MEMORANDUM

TO: Nell Donaldson, Planner
FROM: Ashley Auger, E.I.T. & David Senus, P.E.
DATE: November 6, 2013
RE: 130 Eastern Promenade, Level II Site Plan Amendment

Documents Reviewed by Woodard & Curran

- Level II Site Plan Amendment and attachments, dated October 16, 2013, prepared by Carroll Associates, on behalf of 130 Eastern Promenade, LLC.
- Drainage Plan, Sheet D-1.0, revised October 11, 2013, prepared by Carroll Associates, on behalf of 130 Eastern Promenade, LLC.
- Landscape Architect Plans, Sheets L-1.0-5.0, & L-5.1 revised October 15, 2013, prepared by Carroll Associates, on behalf of 130 Eastern Promenade, LLC.

L-5.1

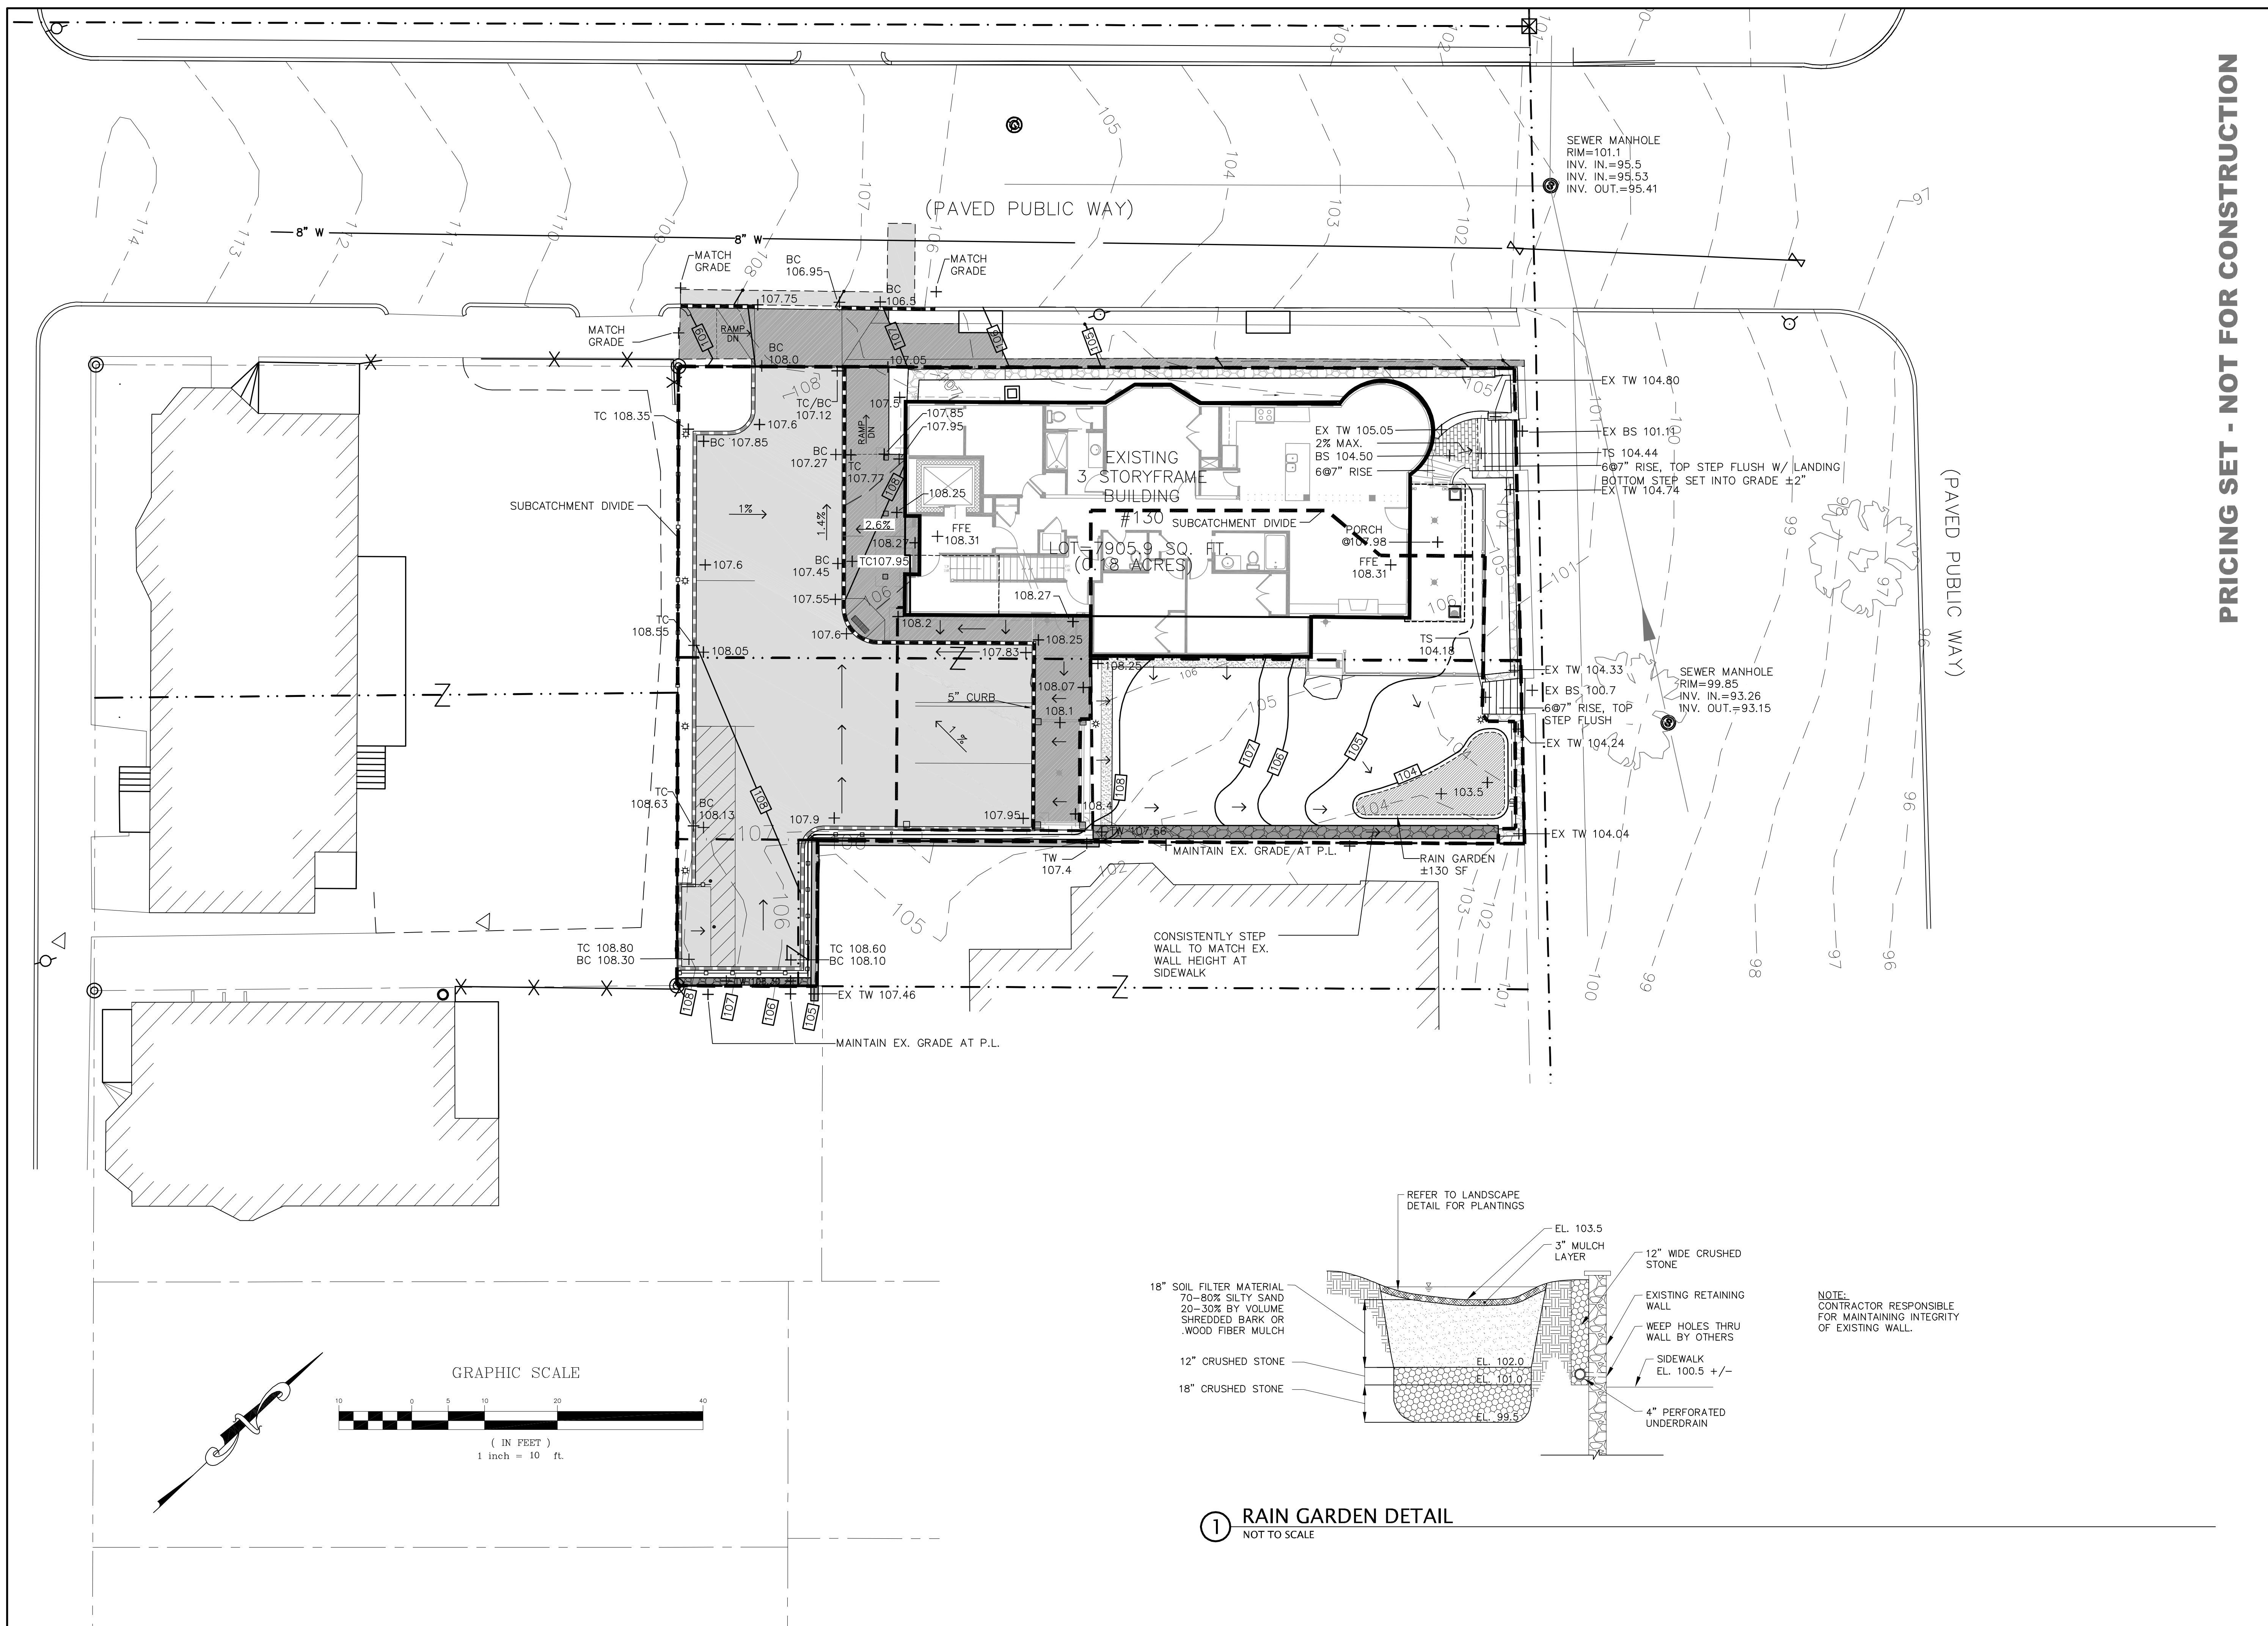
1. The rain garden details on sheet D-1.0 and the retaining wall detail on L-5.1 indicate that an underdrain will exist below the rain garden and at the base of the retaining wall; however, no underdrains are depicted on the site plans. If an underdrain is required for these systems, we encourage day-lighting the underdrain(s) in lieu of a direct connection to the combined sewer; clarification should be provided on the plans and/or details.
